Our ref: HA/2020/122528/01-L01
Your ref: LU/163/20/PL

DEMOLITION OF EXISTING CONSERVATORY, SINGLE STOREY FRONT & REAR EXTENSIONS & CHANGE OF USE FROM HMO (SUI GENERIS) TO 5 NO. FLATS (4 NET) (C3 DWELLING HOUSE). THIS APPLICATION AFFECTS THE CHARACTER & APPEARANCE OF THE LITTLEHAMPTON SEAFRONT CONSERVATION AREA & MAY AFFECT THE SETTING OF A LISTED BUILDING. THIS APPLICATION IS NOT CIL LIABLE AS FLATS IN ZONE 4 (ZERO RATED).

6 SELBORNE PLACE SELBORNE ROAD LITTLEHAMPTON BN17 5NH

Environment Agency Position

drawing title
Proposed Plans
-
PLANNING

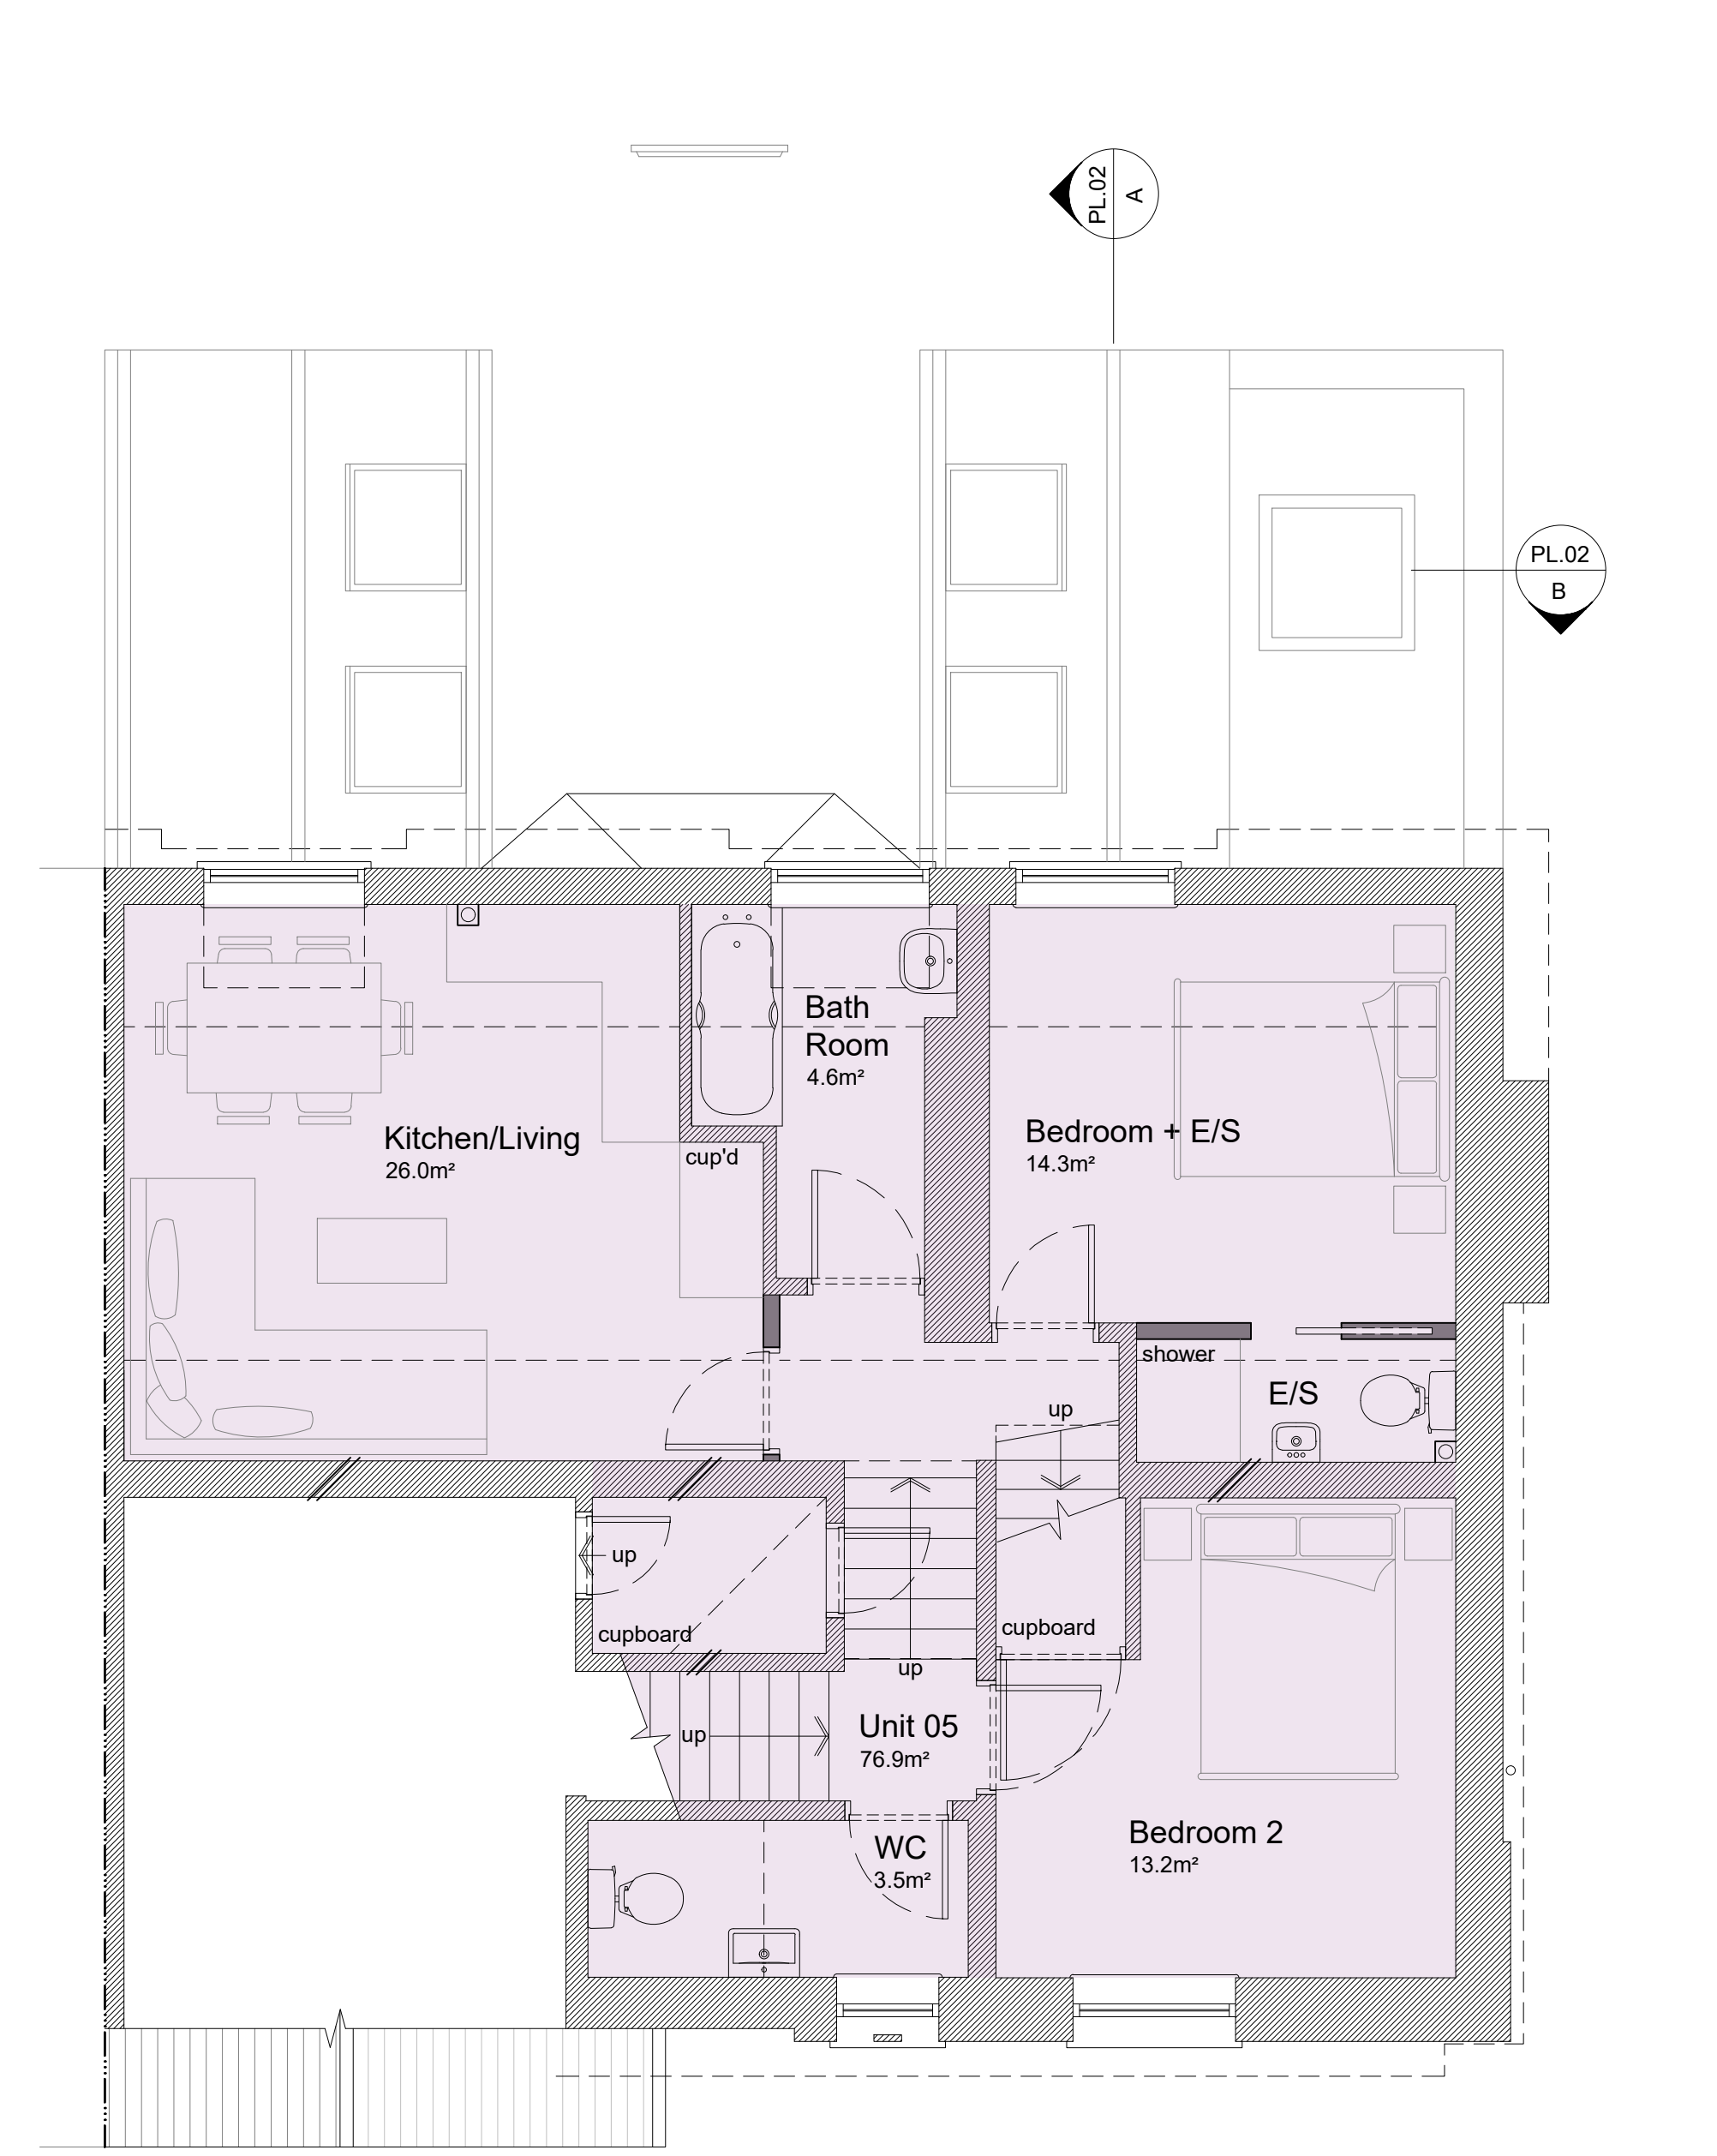
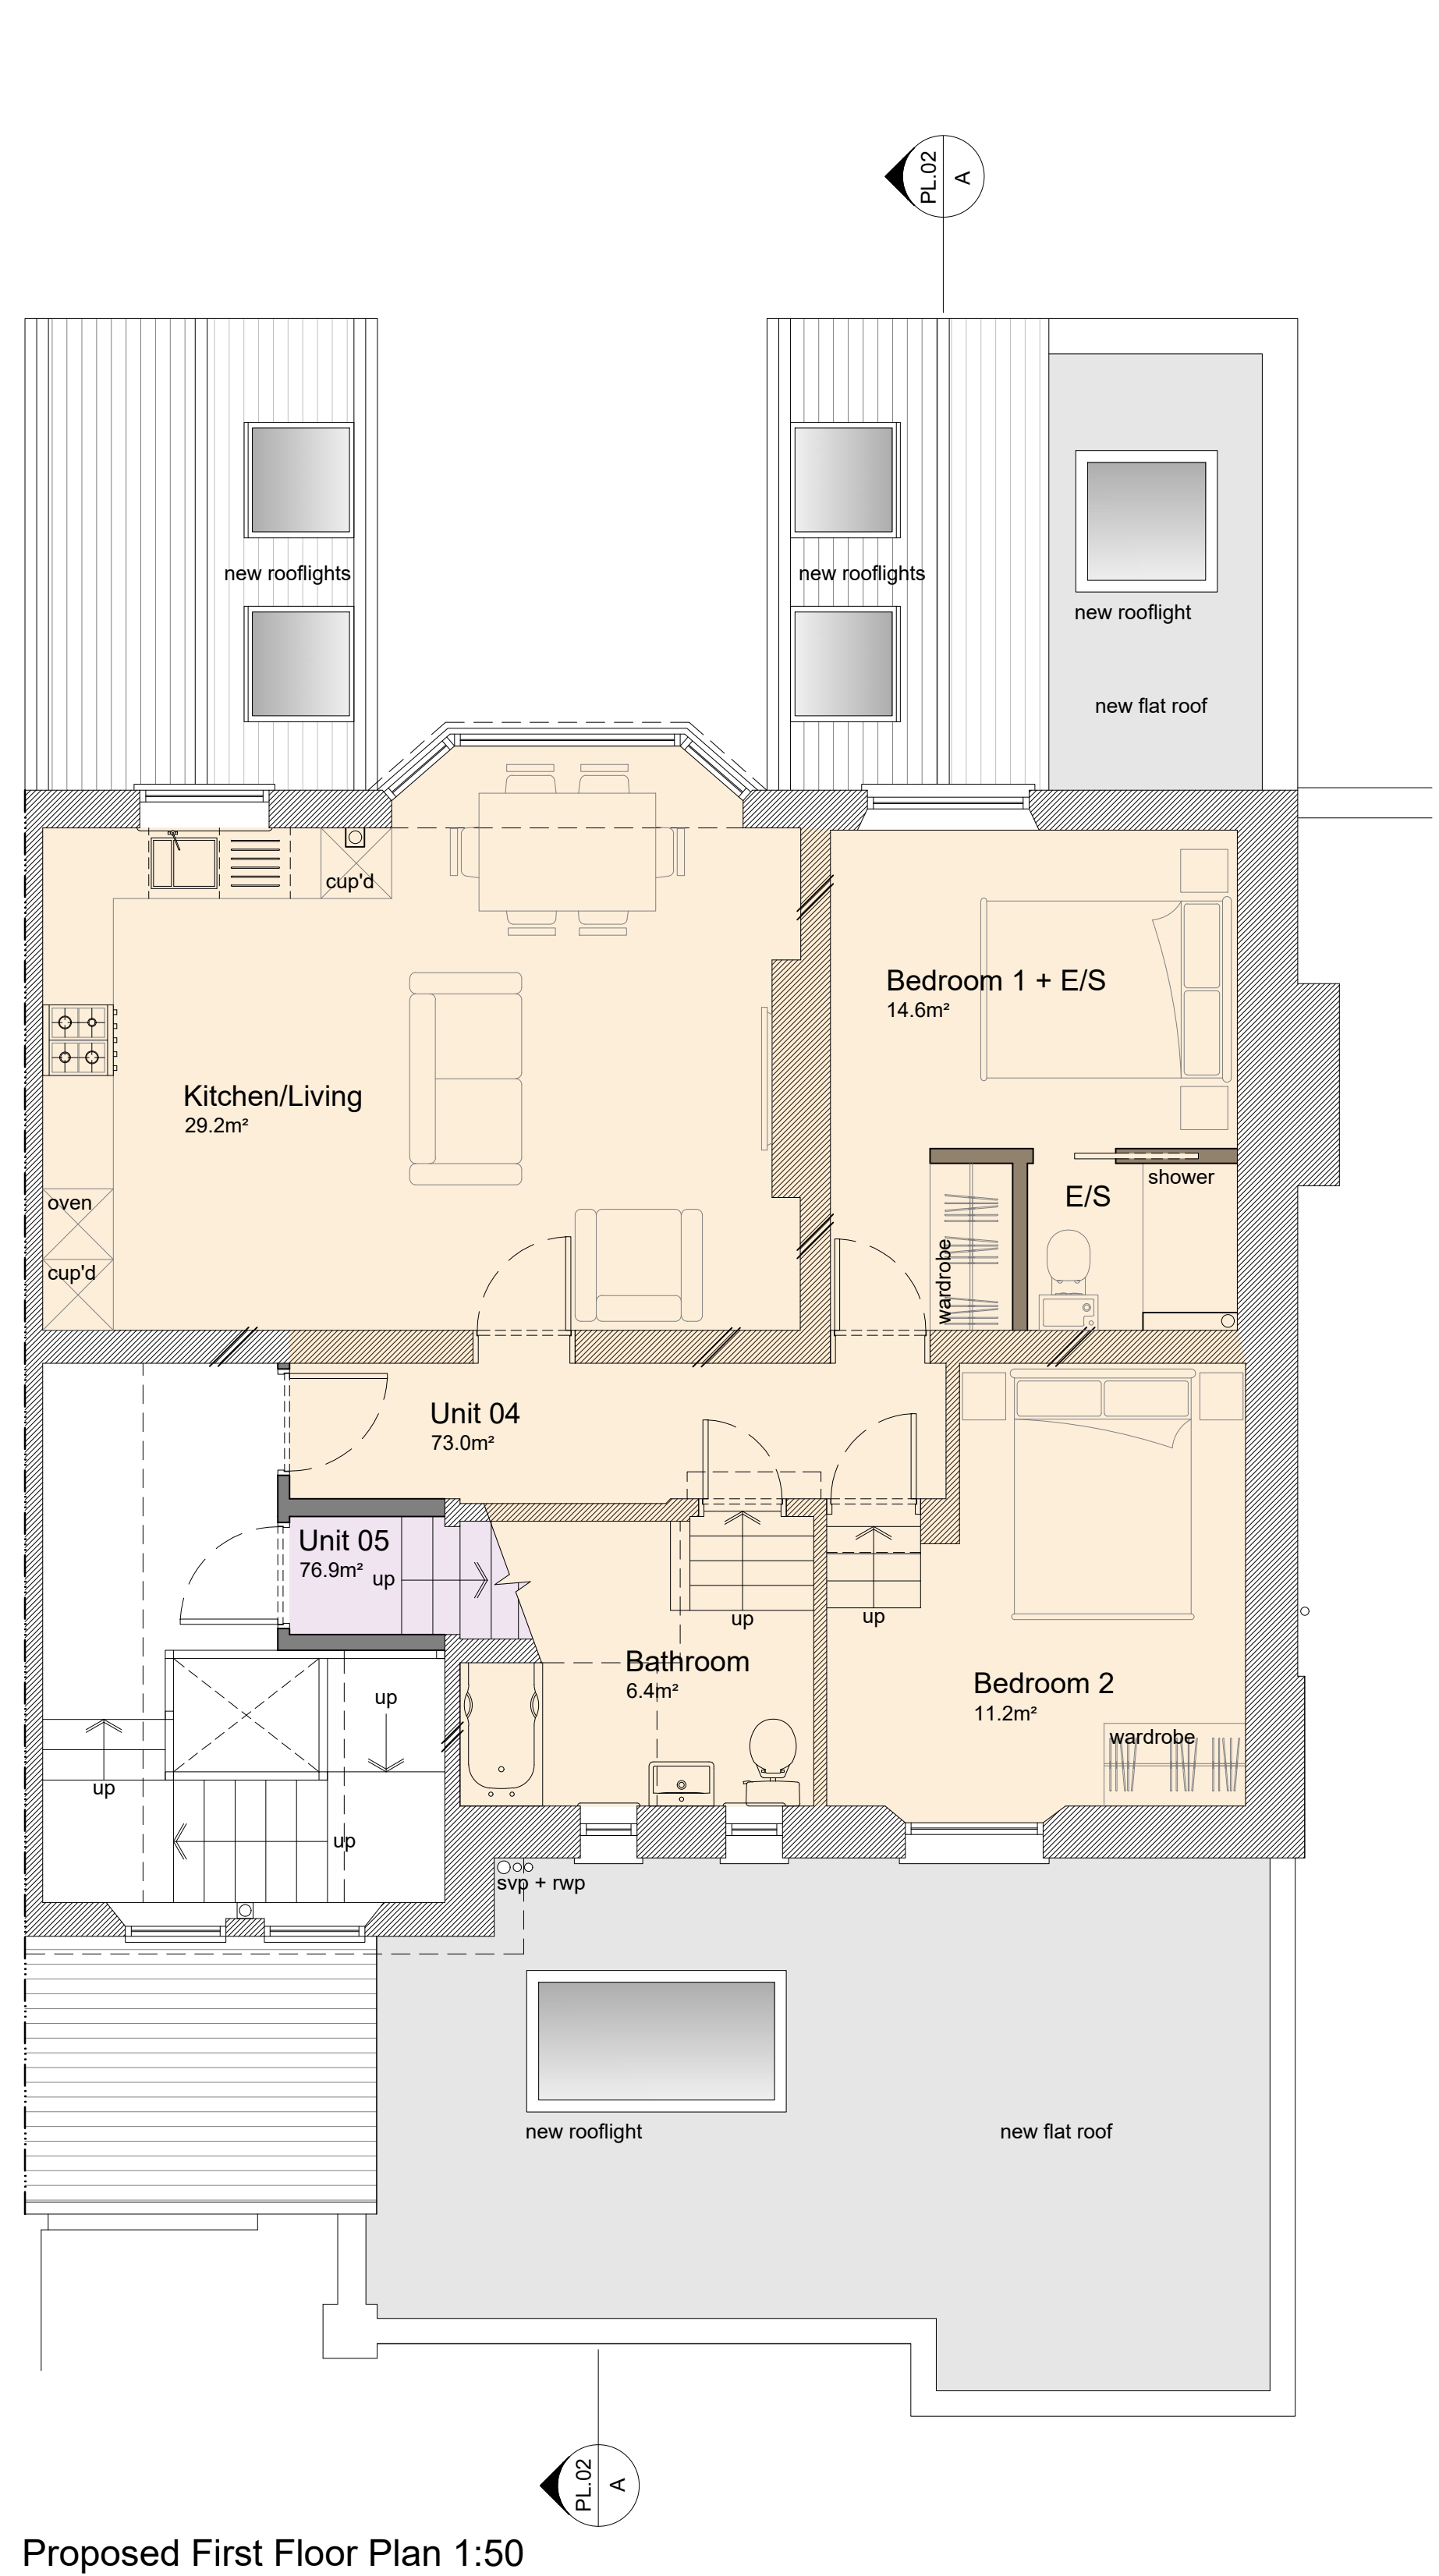
- consider how residents in the proposed ground floor bedrooms will be kept safe from the identified flood hazards in the Flood Risk Assessment.
- consider the requirement for flood emergency planning including flood warning and evacuation of people for a range of flooding events up to and including the extreme event

example will flood resilience products be installed to prevent flood water ingress to the ground floor where residents will be sleeping, will there be warning and evacuation procedures.

To overcome our objection, the applicant should submit a revised FRA which addresses the points highlighted above. The original FRA has identified the flooding risks, however further information on mitigation actions for those risks will need to be provided, for
